From: Christopher Fraser
Sent: Friday, 15 January 2021 4:34 PM
To: Paul Mitchell; Carlo Di Giulio
Subject: DA S29/3/97-Mod-1 - Modification to 50 Peter Brock Drive, Eastern Creek – Event Parking Area - Submission from Blacktown Council

From: Bertha Gunawan <Bertha.Gunawan@blacktown.nsw.gov.au>
Sent: Thursday, 14 January 2021 7:35 PM
To: Christopher Fraser <Christopher.Fraser@planning.nsw.gov.au>
Cc: Tony Merrilees <Tony.Merrilees@blacktown.nsw.gov.au>; Alan Middlemiss <Alan.Middlemiss@blacktown.nsw.gov.au>
Subject: HPE CM: RE: Modification to 50 Peter Brock Drive, Eastern Creek – Event Parking Area (DA S29/3/97-Mod-1)

Amended drainage plans are required to be provided to Council to demonstrate and address the following issues:

DRAWING TITLE				
DRAINAGE DETAILS SHEET 1				
PROJECT NO.	PLANSET NO.	RELEASE NO.	DRAWING NO.	REVISION
P2108122	PS01	R02	PS01-E200	A

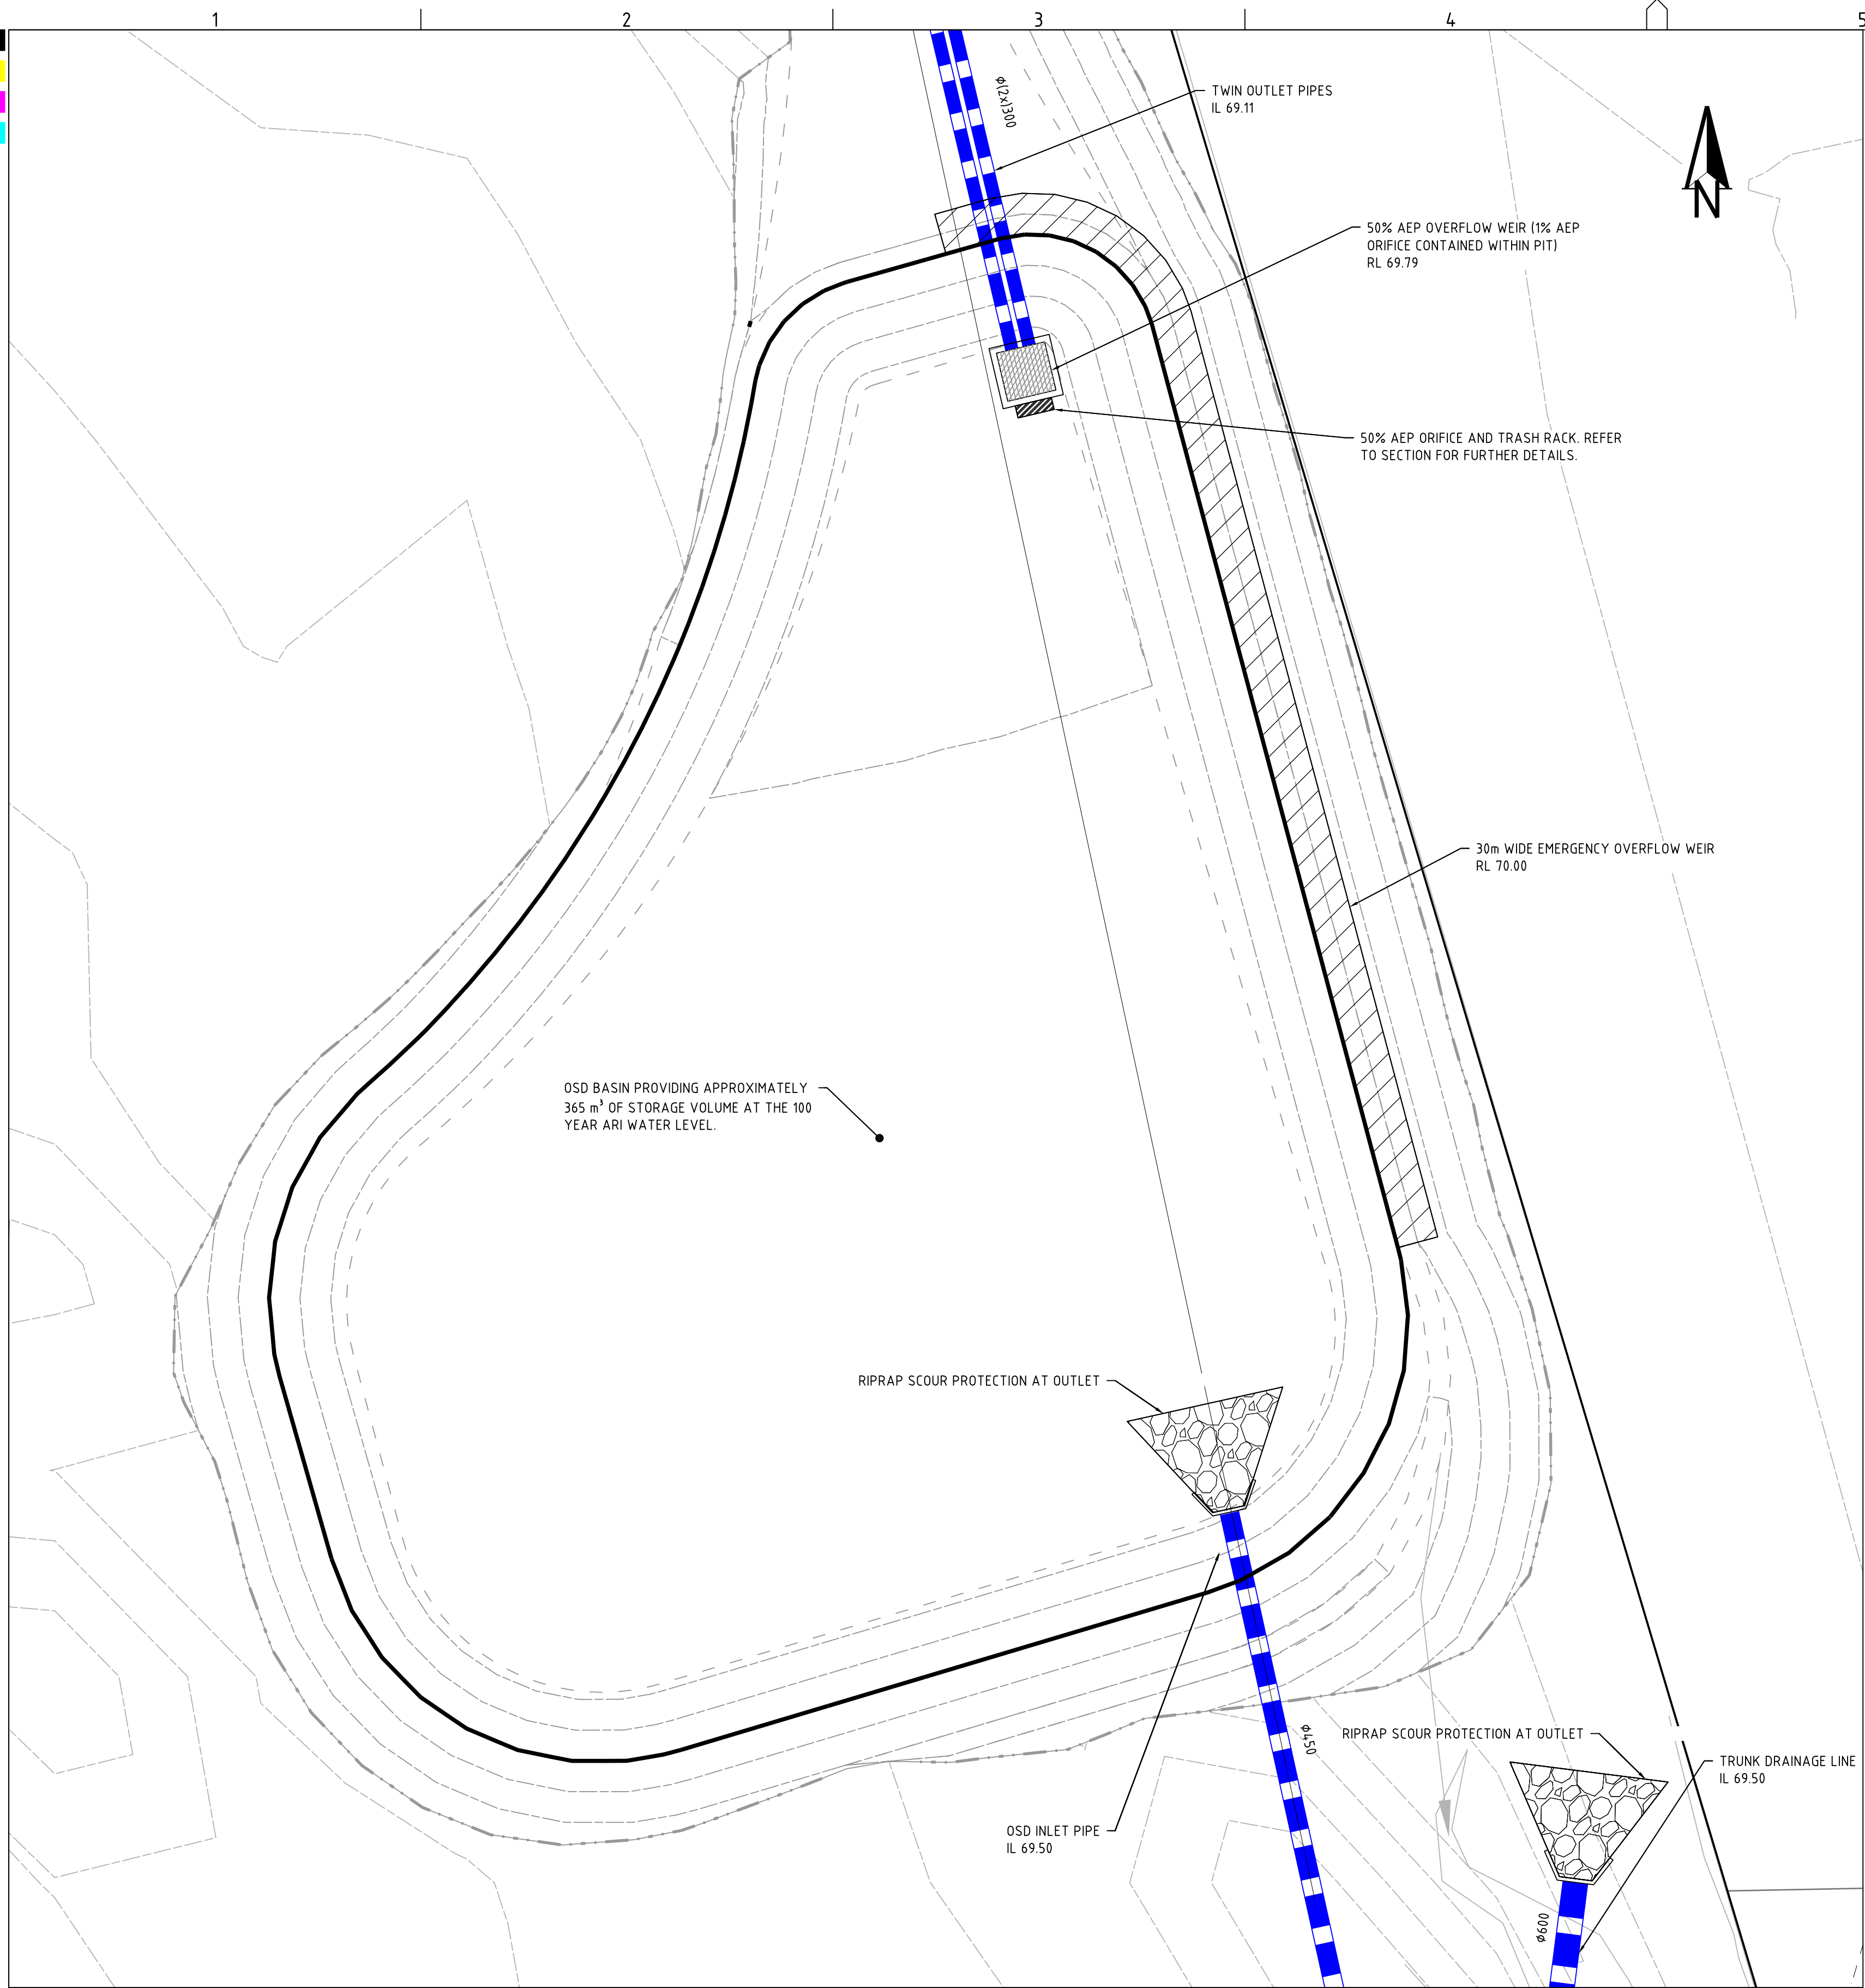
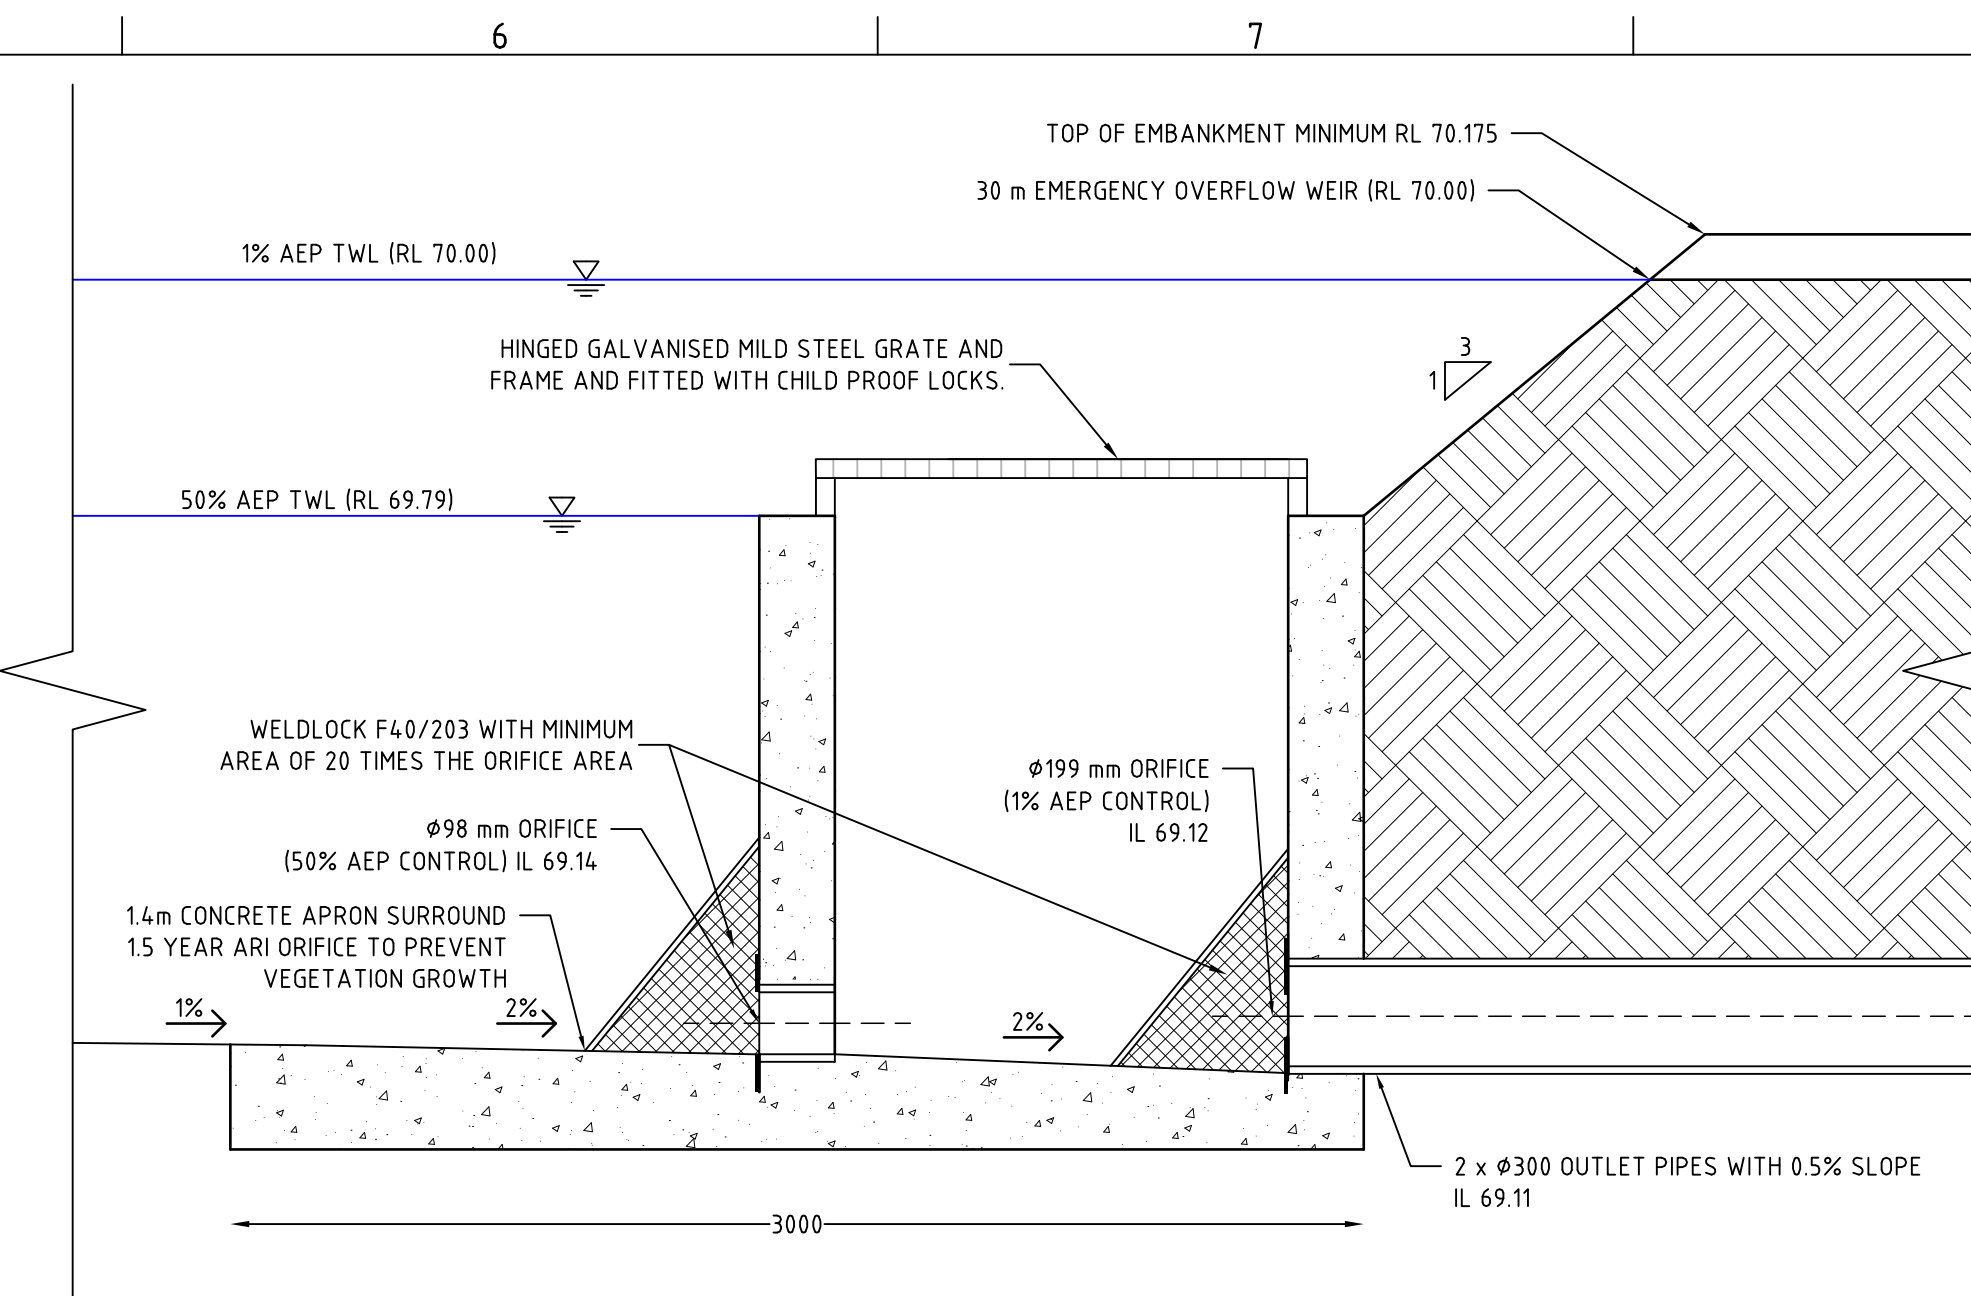
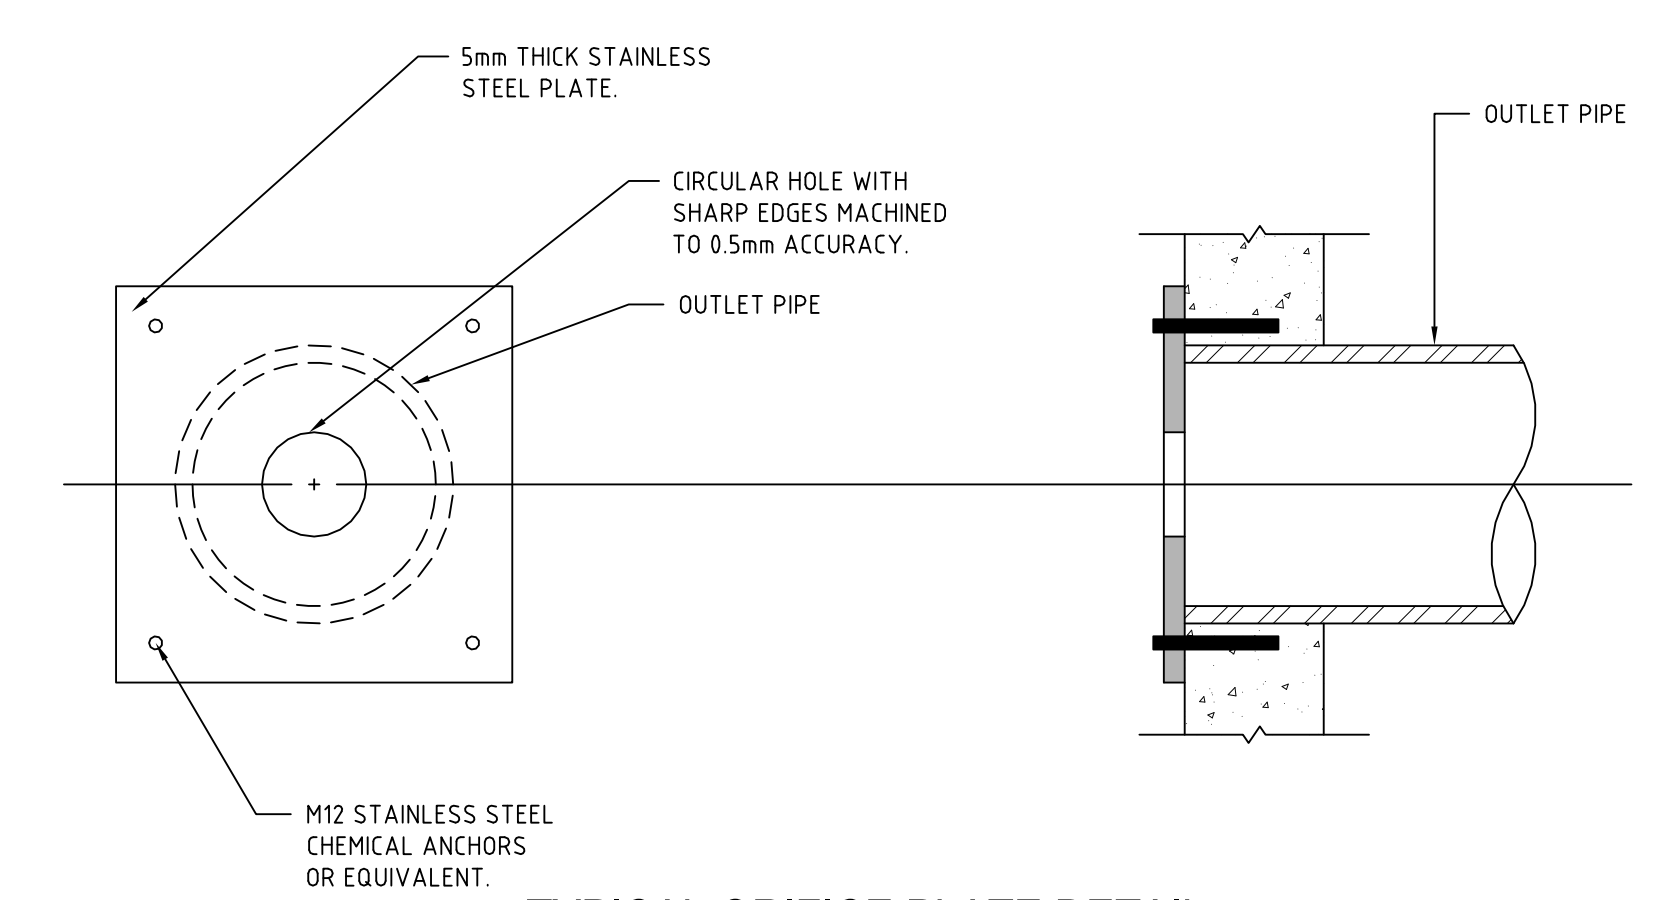
- 1. All works to be compliant with Council's Engineering Guide for Development and the WSUD developer handbook 2020.*
- 2. On-site detention to be provided for the new works as per the above documents using Council's OSD Deemed to Comply Spreadsheet available from Council and as per the details in Council's WSUD standard drawings A(BS)175M. Provide detailed plans with sections for Council to assess.*
- 3. Provide a MUSIC model digitally to Council to review water quality targets as detailed under Part J of DCP2015 using the requirements of the WSUD developer handbook 2020.*
